## ***Rezoning Petition Review***

**Date of Review:** September 27, 2021 ***(Revised January 24, 2022)***

**Rezoning Petition #:** 21-112

**Location of Property:** Approximately 20.10 acres located on the east and west side of Ikea Blvd, south of University City Blvd and east of N Tryon St.

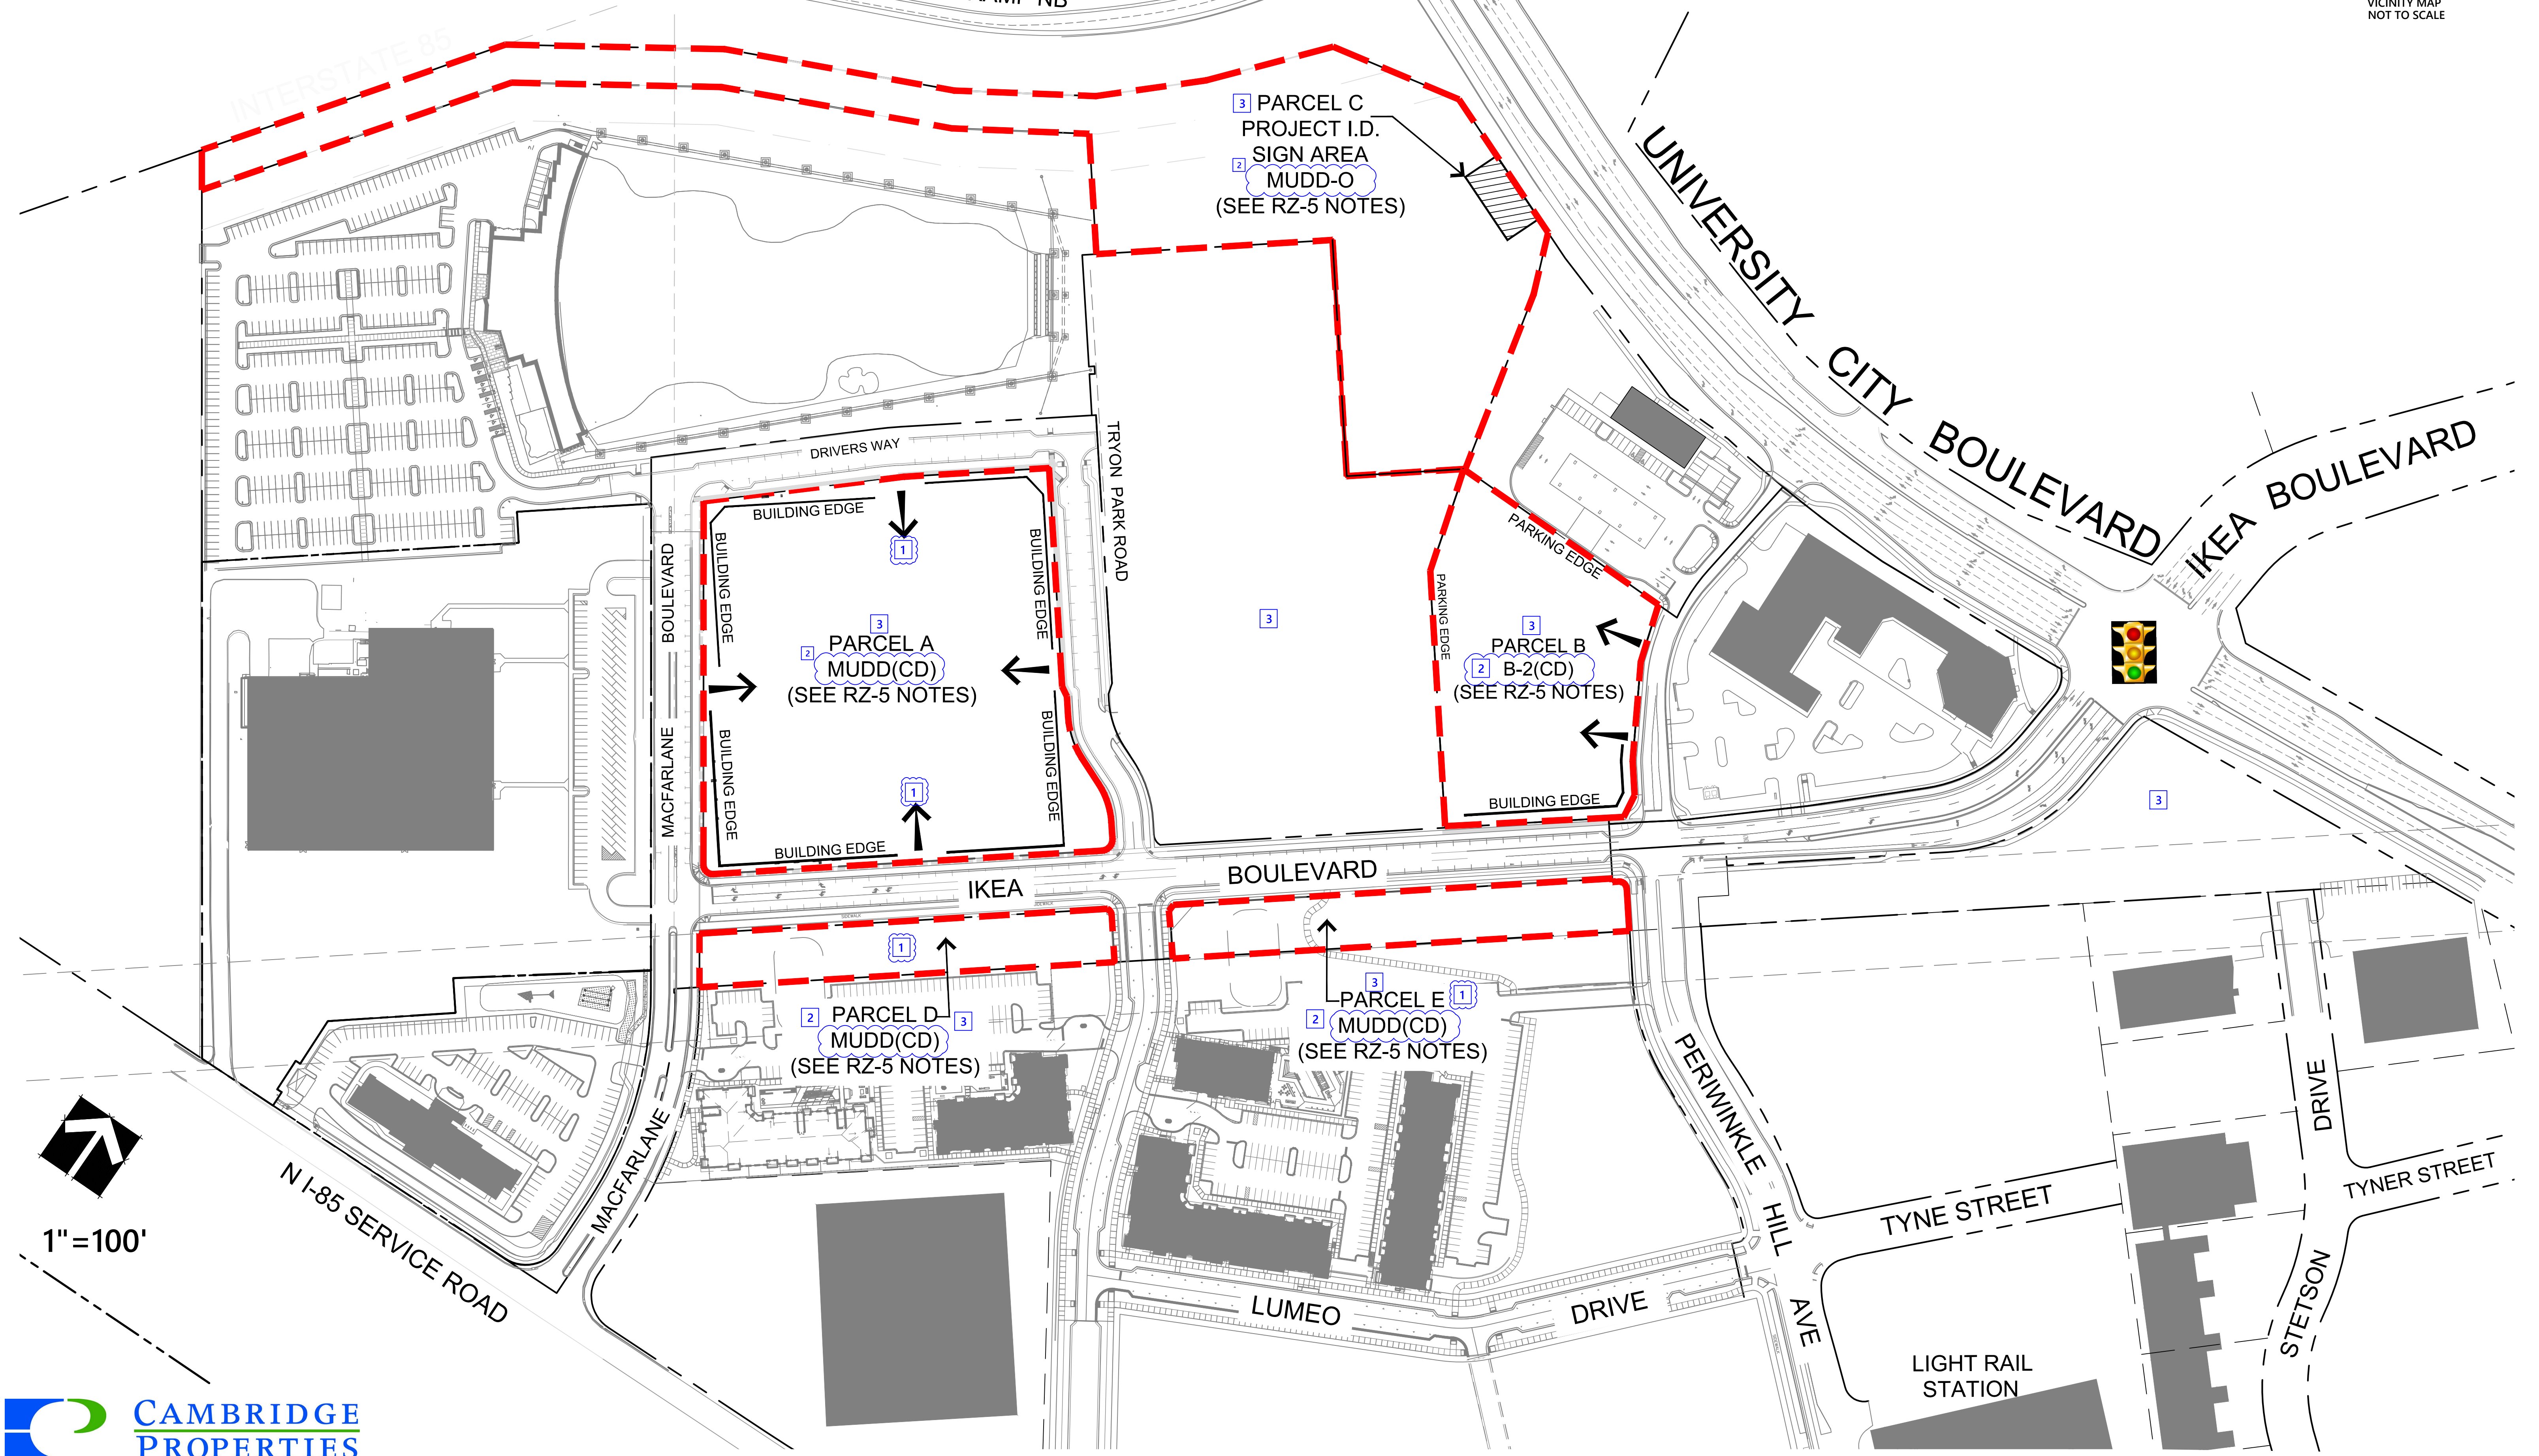
**Recommendations Concerning Storm Water:** Please remove note 6 in its entirety and replace with the following:  
*The petitioner shall comply with the Charlotte City Council approved and adopted Post Construction Stormwater Ordinance.*

Please include the following note under Environmental Features:  
*“Development within any SWIM/PCSO Buffer shall be coordinated with and subject to approval by Charlotte-Mecklenburg Storm Water Services and mitigated if required by City ordinance. Petitioner acknowledges intermittent/perennial stream delineation reports are subject to review and approval upon submission of development plans for permitting and are not approved with rezoning decisions.”*

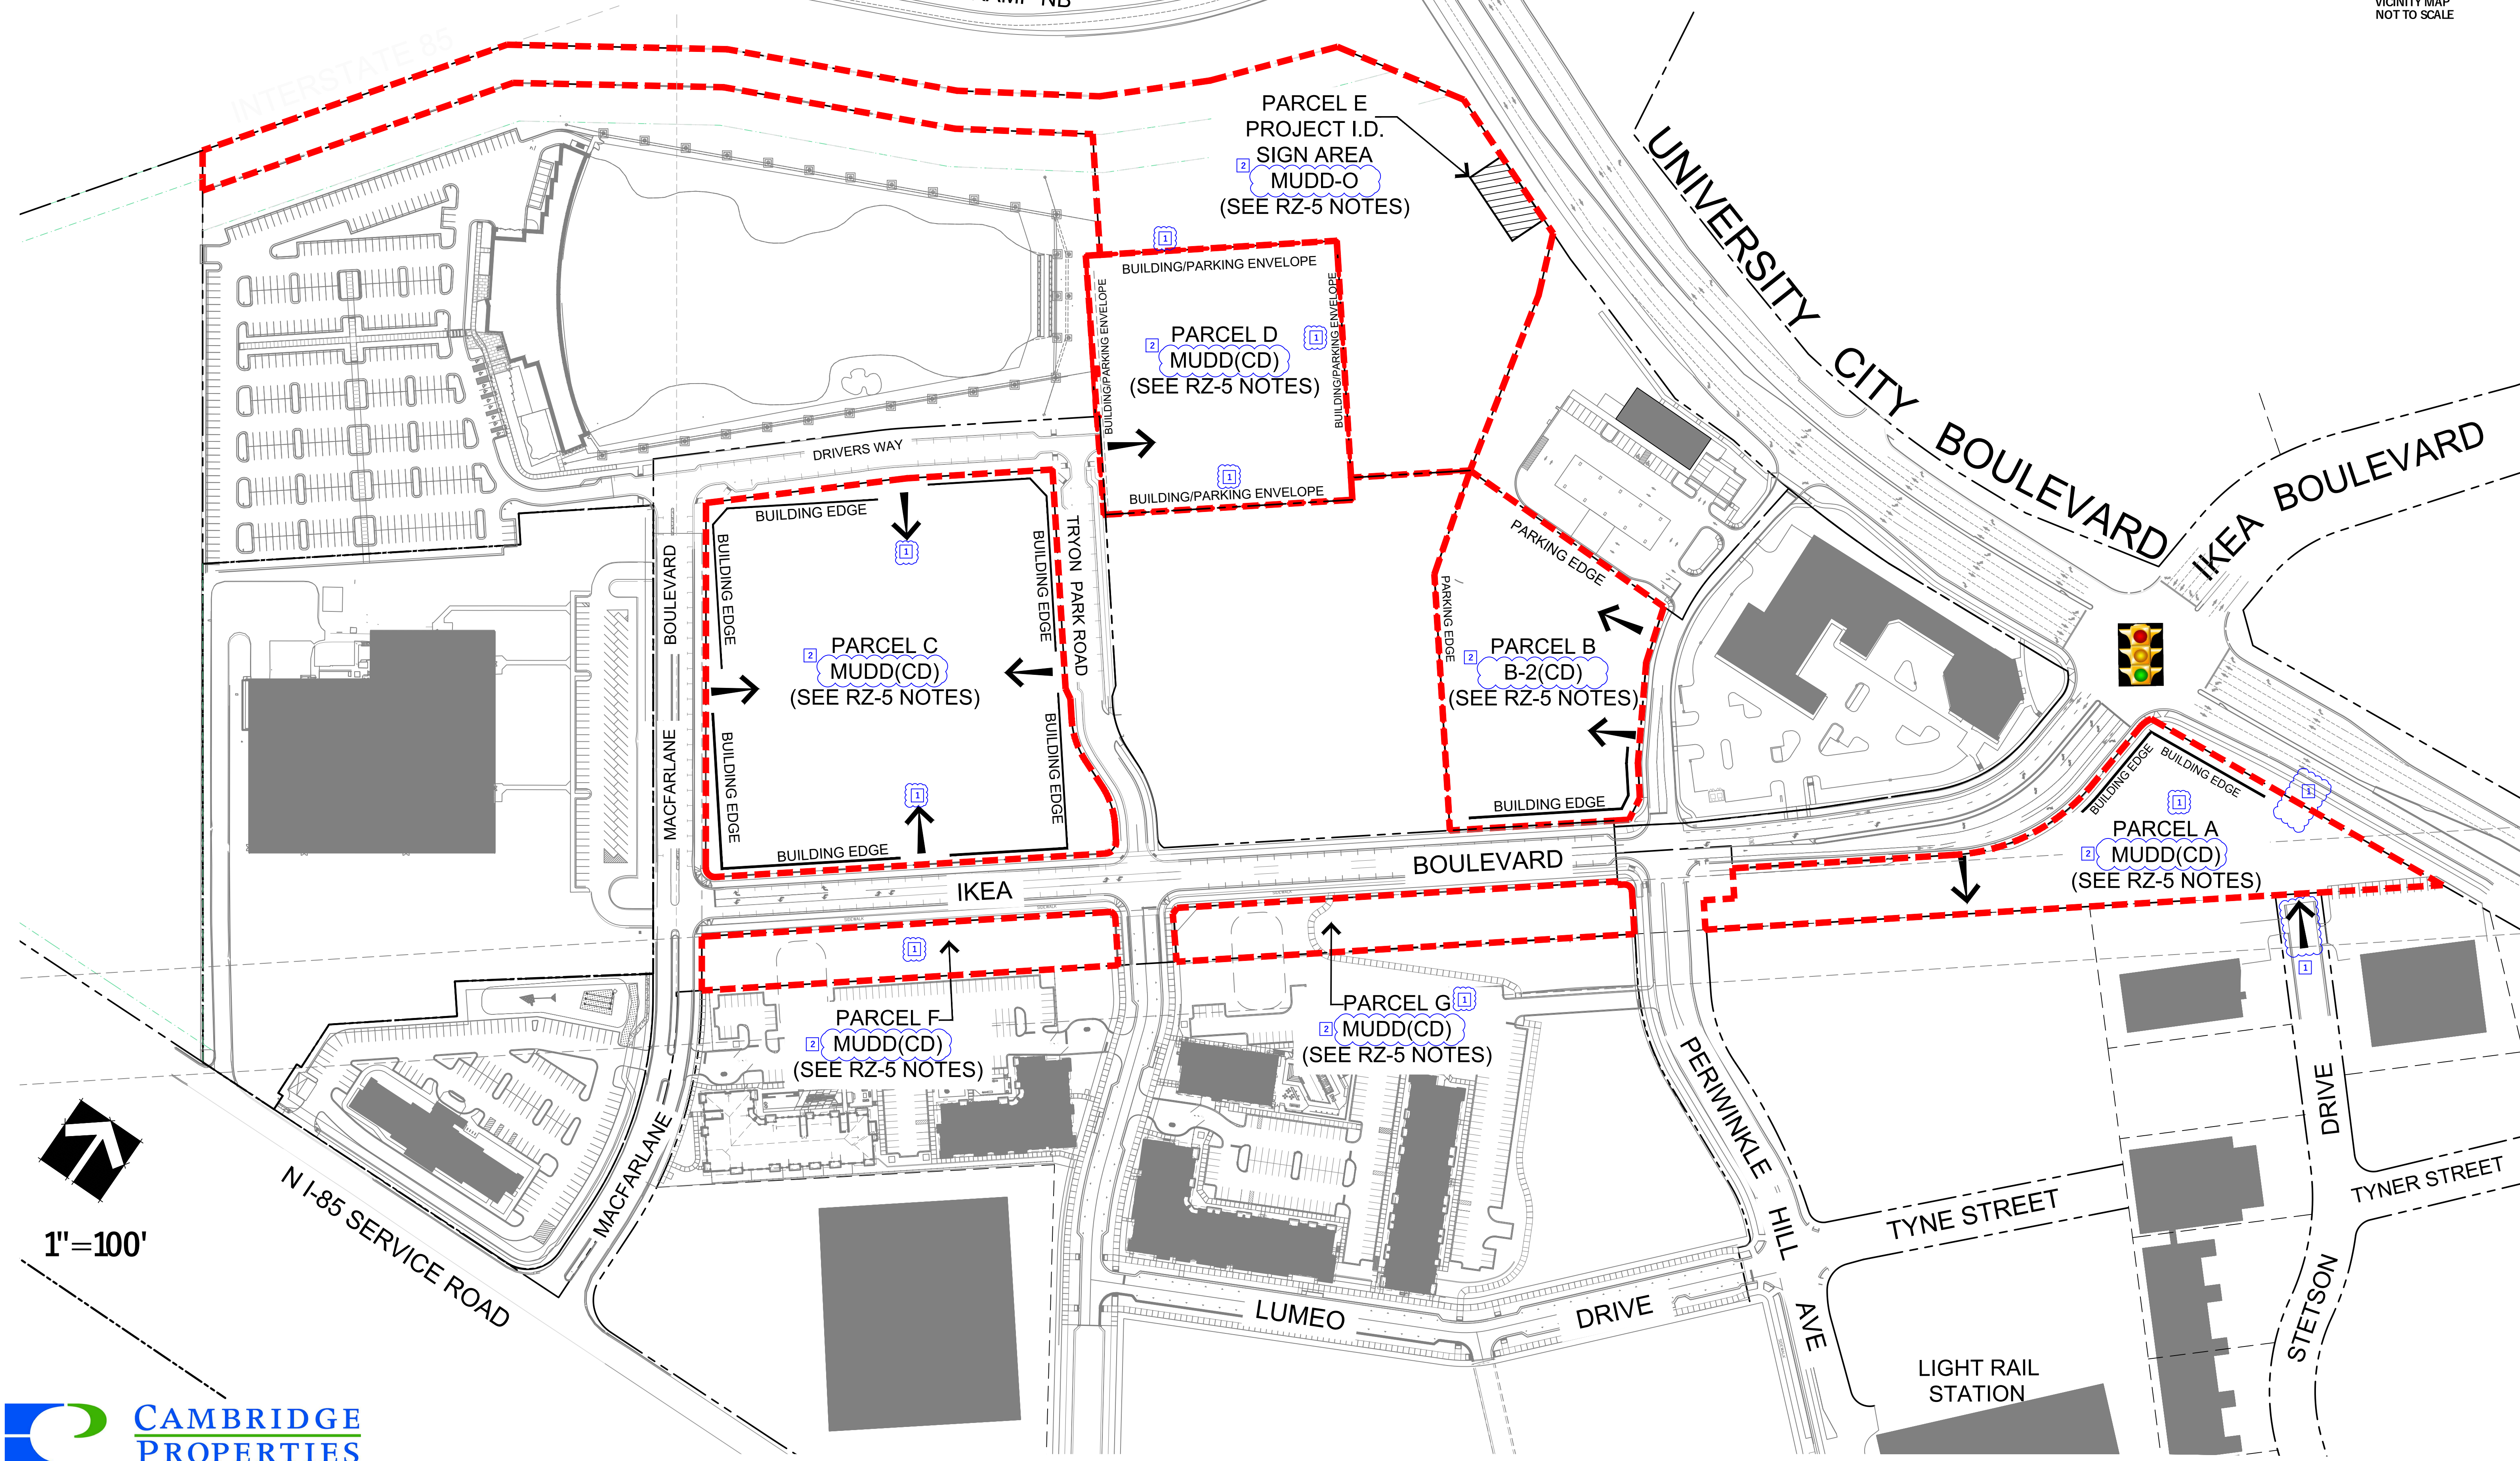
***Due to revisions (11/29/21):*** City of Charlotte GIS indicates a 35-ft SWIM Buffer and a 100-ft Undisturbed PCSO Buffer on site. Please show and label potential SWIM/PCSO Buffers on the site plan.

***Due to revisions (1/24/22):*** No additional recommendations are needed at this time.
